From: Amanda Scholes on behalf of Planning.Responses
Sent: 30 March 2021 10:08
To: Planning Scanning
Subject: FW: Planning Consultation on: LY/4/21/DOC

From: Paul Cann <Paul.Cann@arun.gov.uk>
Sent: 29 March 2021 15:46
To: Planning.Responses <Planning.Responses@arun.gov.uk>
Cc: Finlay Gardner <Finlay.Gardner@arun.gov.uk>
Subject: RE: Planning Consultation on: LY/4/21/DOC

(Relating to condition no.3 of LY/10/17/PL)

Application No: LY/4/21/DOC
Registered: 10th March 2021
Site Address: Comfort Inn Lyminster Road Lyminster BN17 7QQ
Description of Works: Approval of conditions imposed under LY/10/17/PL relating to condition 3-surface water drainage.

TANK SEWER c/w CONTROL CHAMBER & INLET CATCHPIT

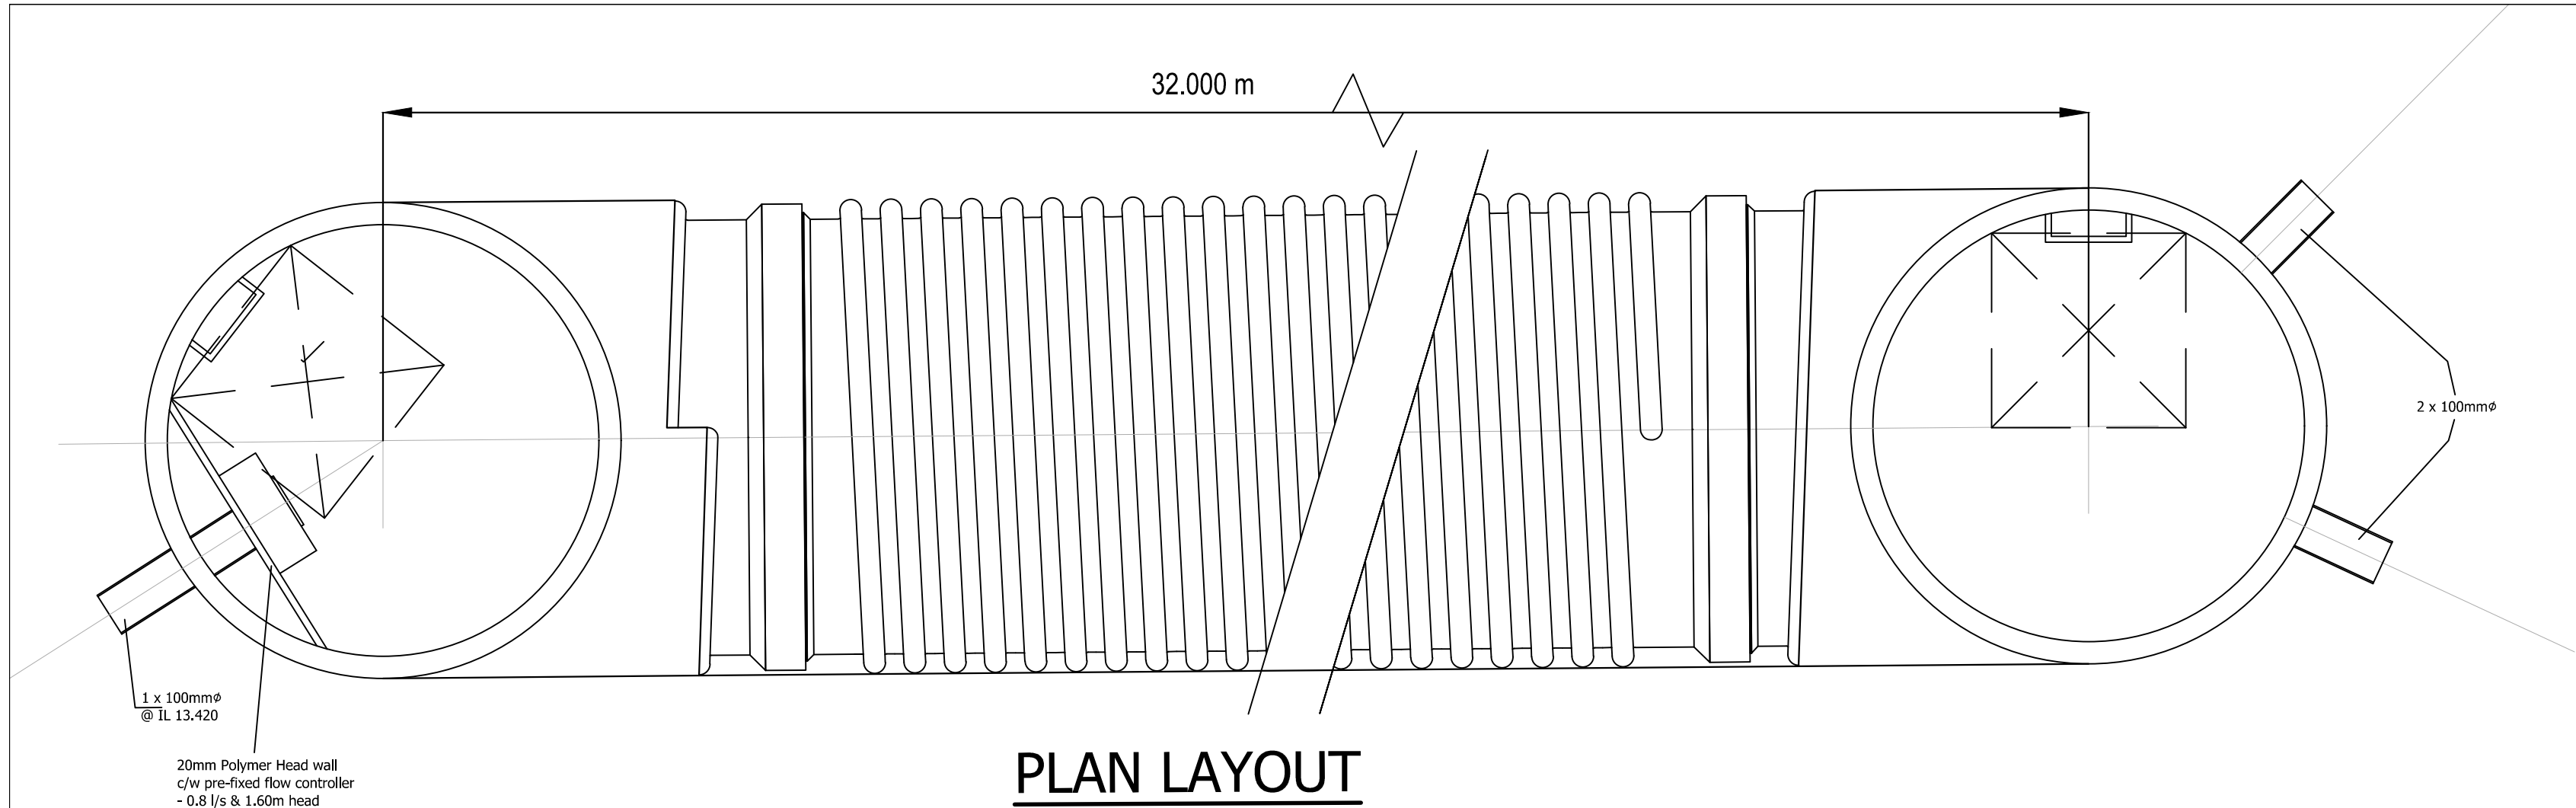
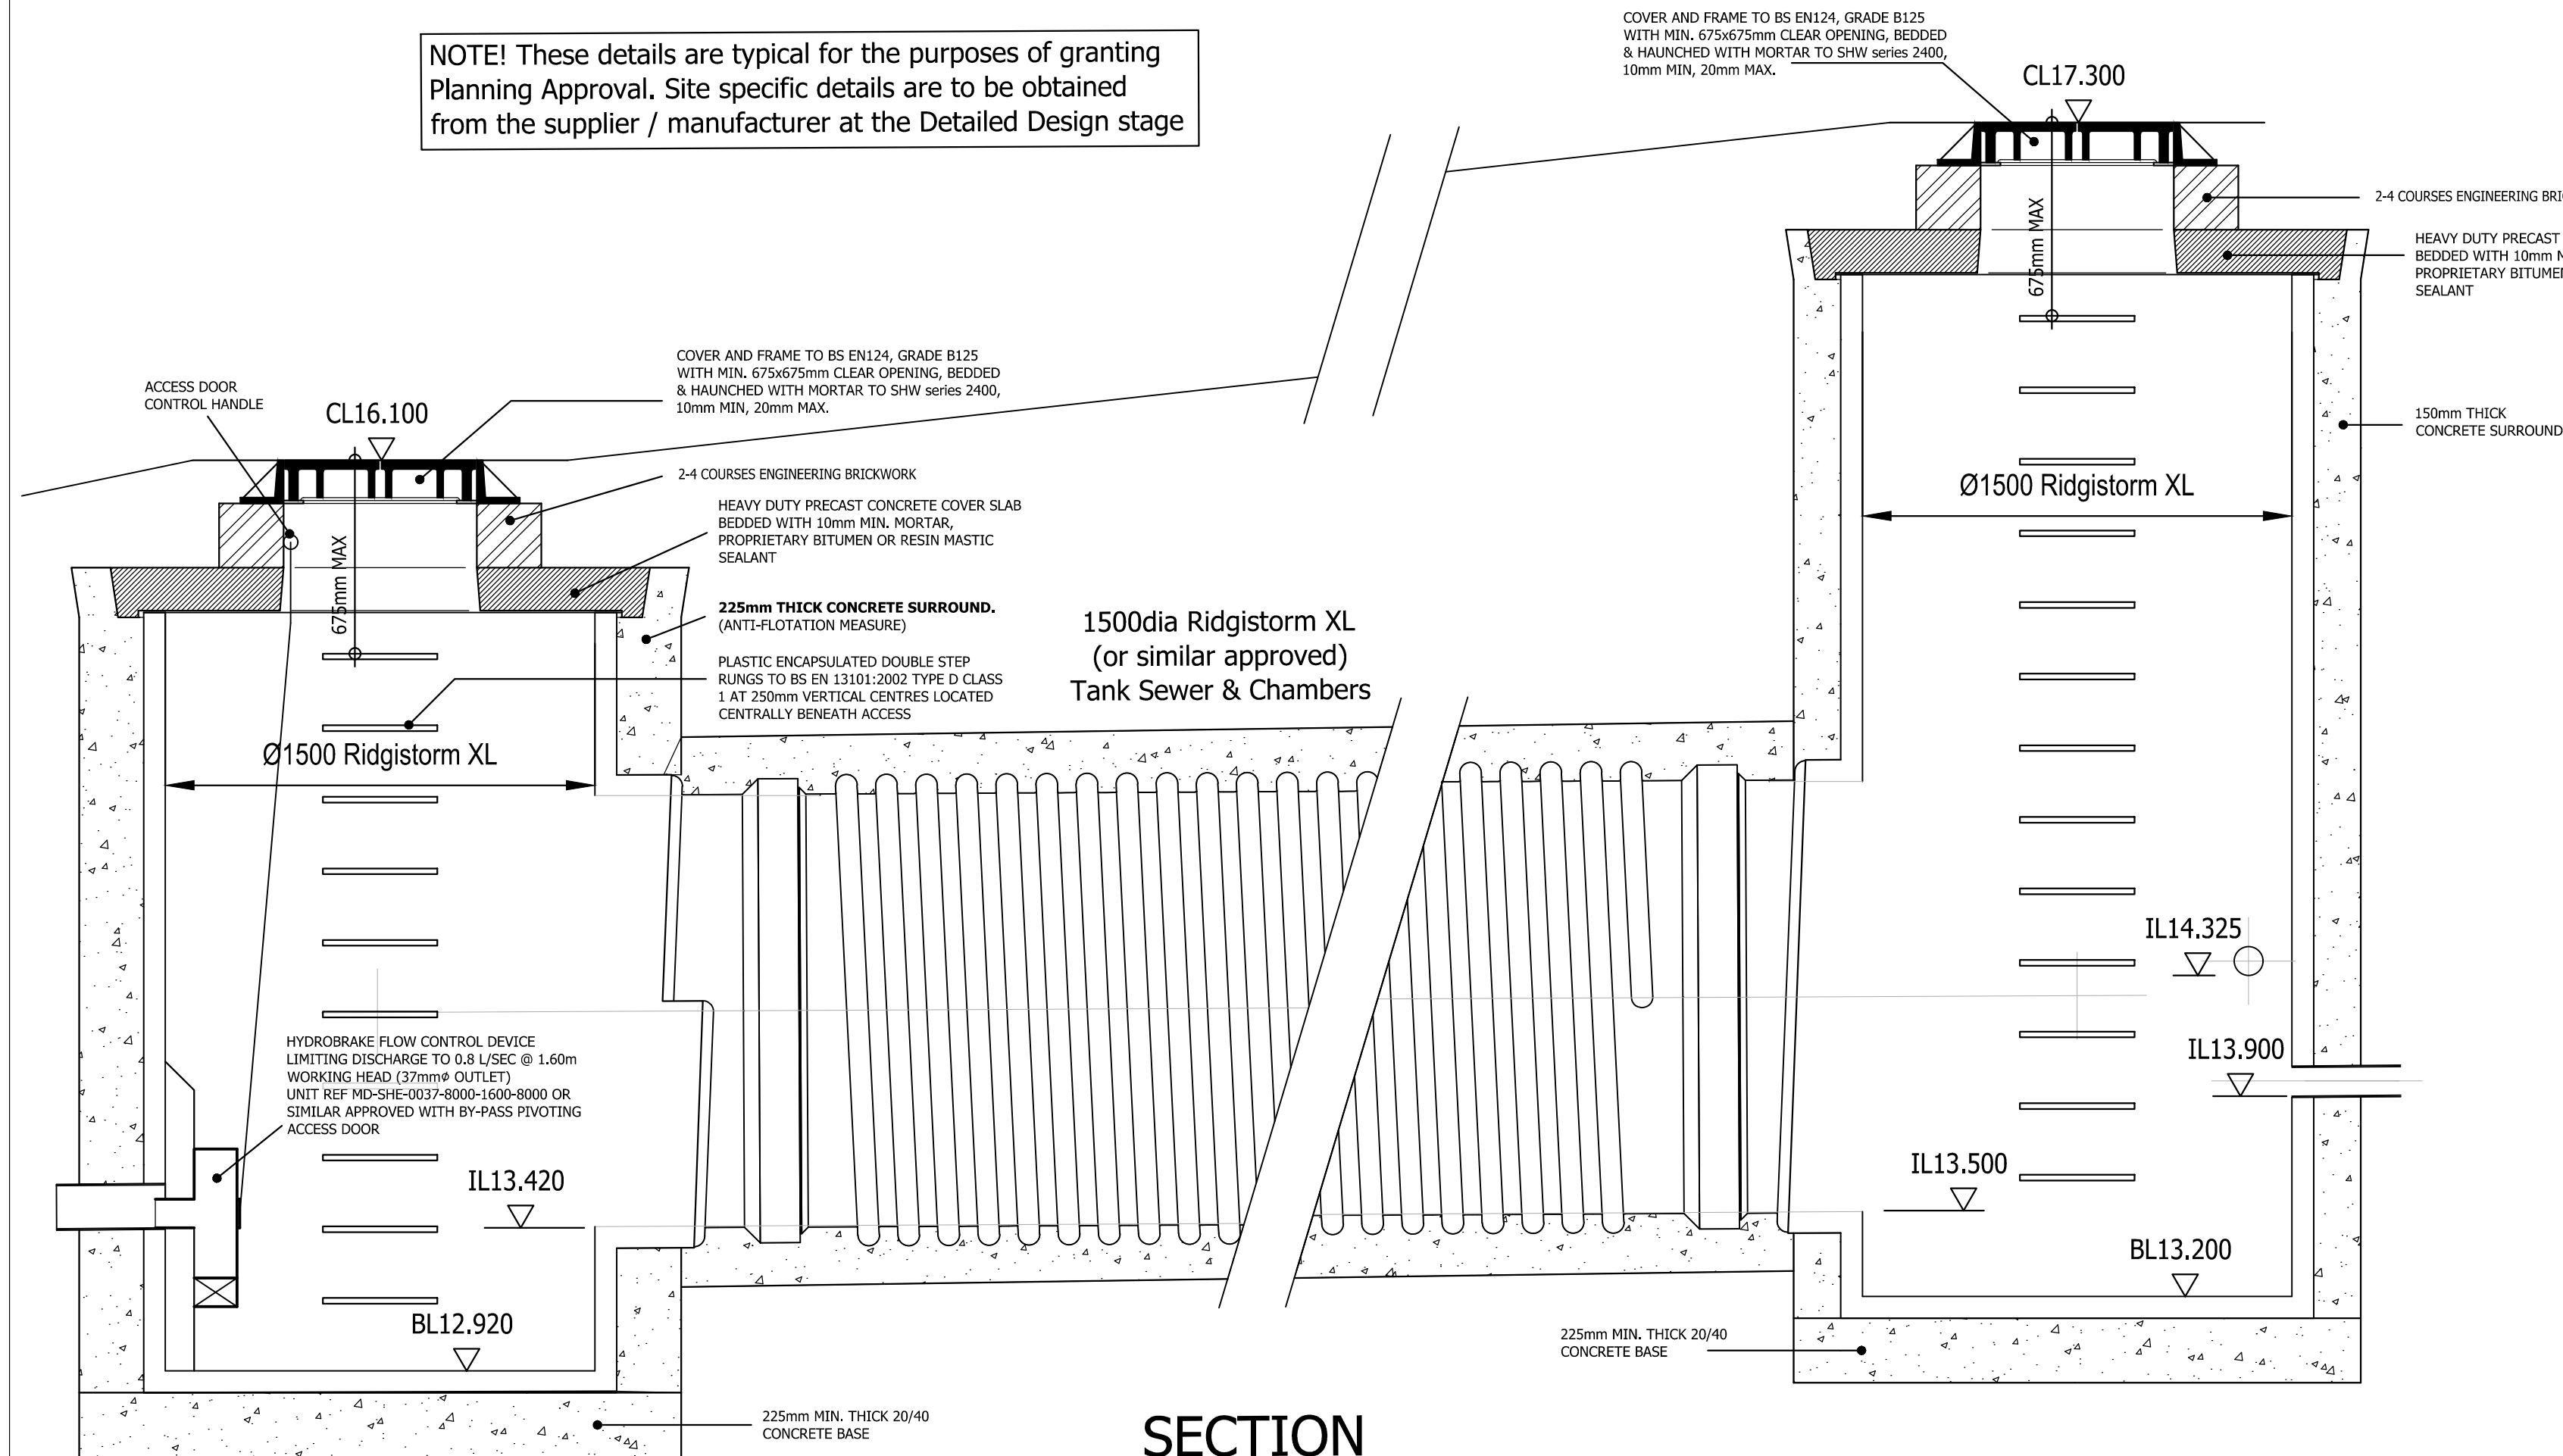
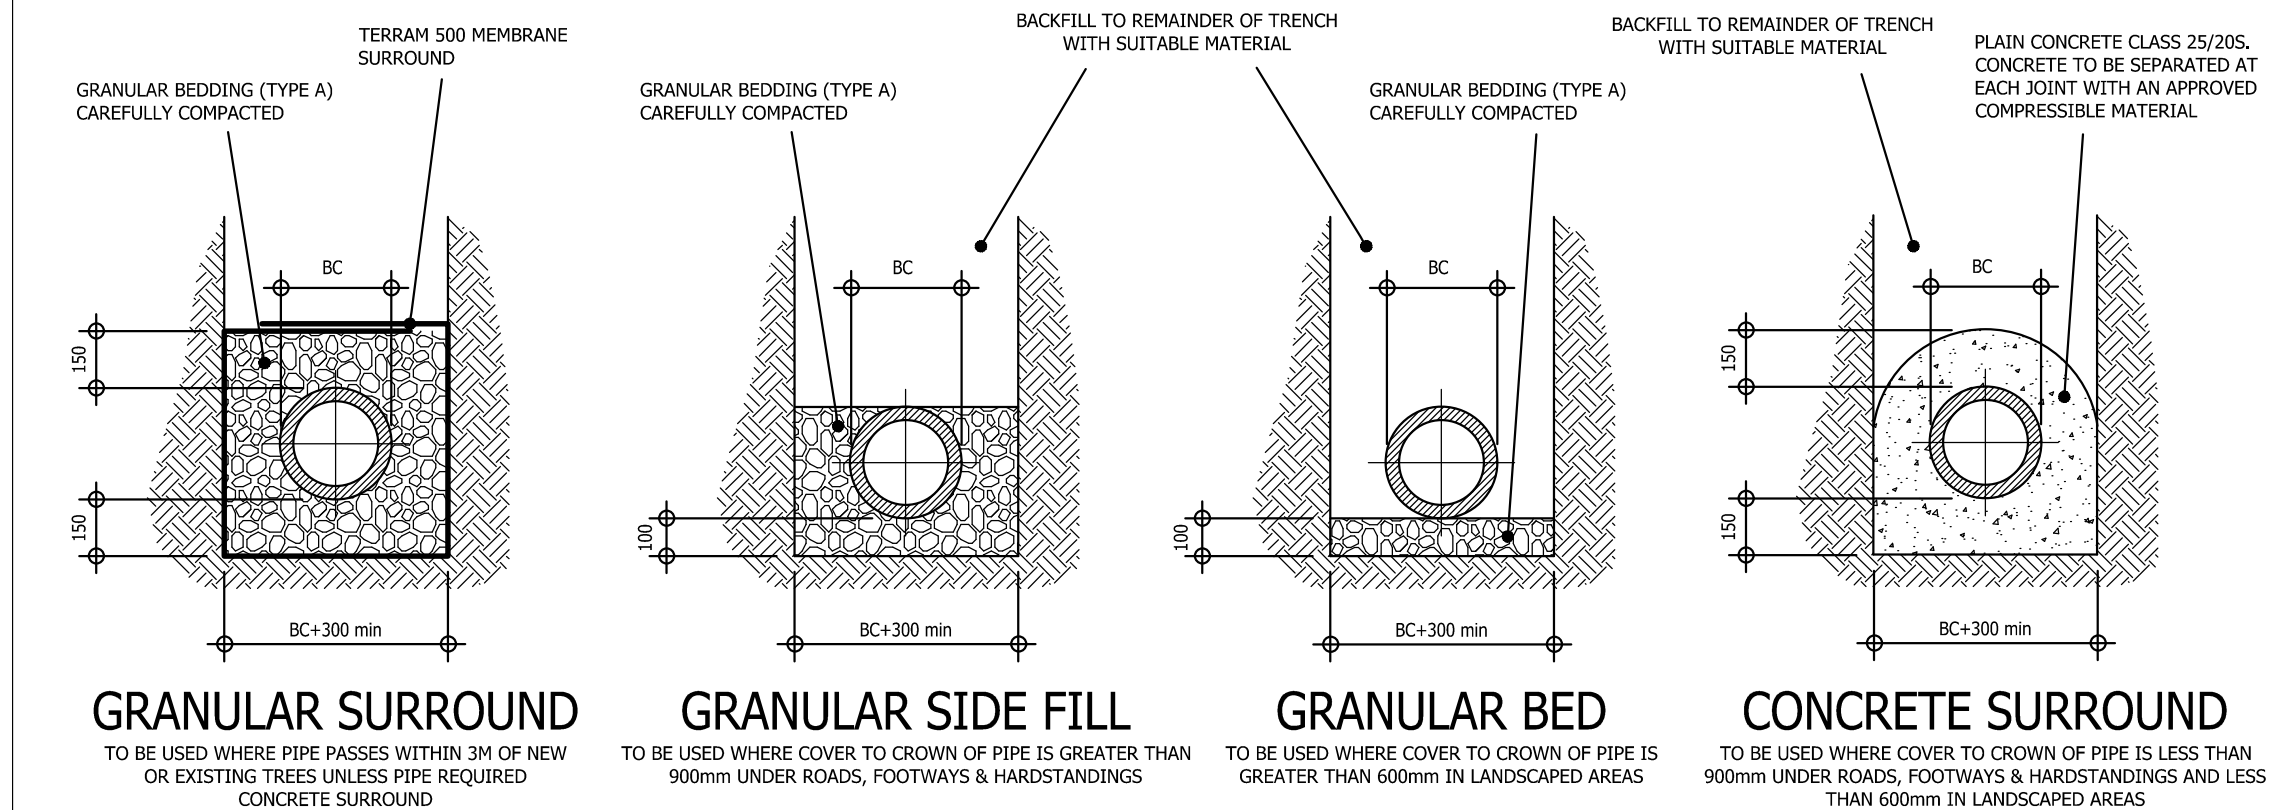
1. The construction details for the storage tank need to reflect the revised levels/outlet orientation, etc.

TYPICAL 'NON ENTRY' TYPE INSPECTION CHAMBER
(NEW CHAMBER ON EXISTING 150mmØ OUTFALL)
(1:10 typical)

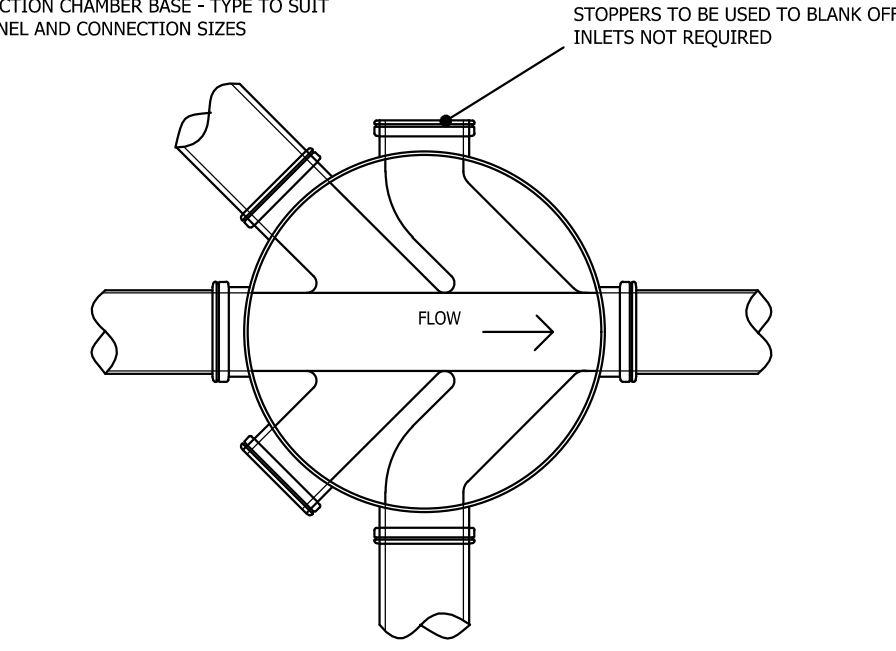
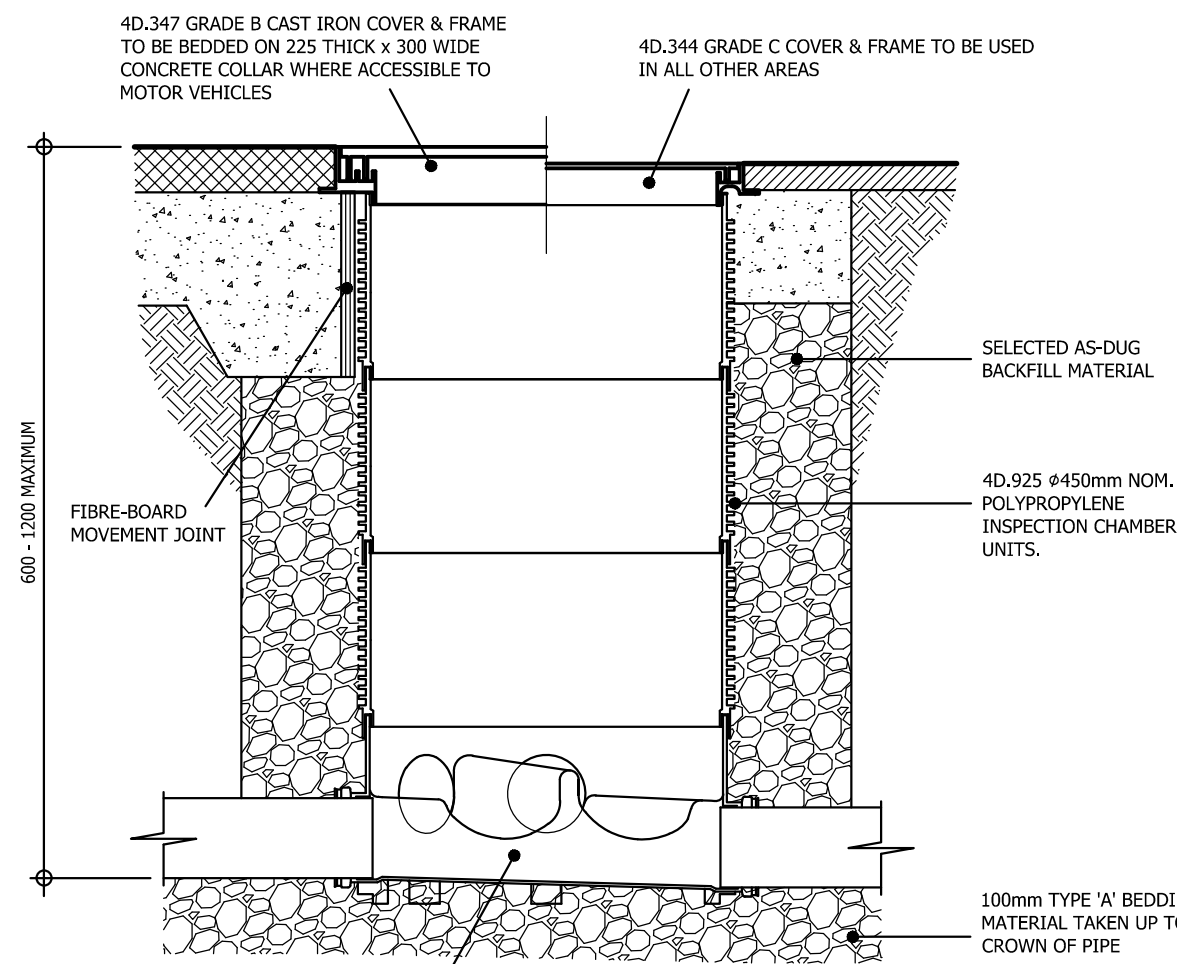
2. Make it clear in terms of the construction detail being referred to for the new manhole to be constructed on the existing 150mm pipe.
3. Specify the invert level of the existing 150mm pipe where it discharges to the existing ditch. Also, the invert level of the manhole upstream of where the pipe is being connected to. Specify the actual invert level at the point of connection, ensuring that the 100mm pipe connects at soffit to soffit level with the 150mm pipe.
4. Specify the actual gradient of the pipe between the control chamber and the new manhole on the existing 150mm pipe.
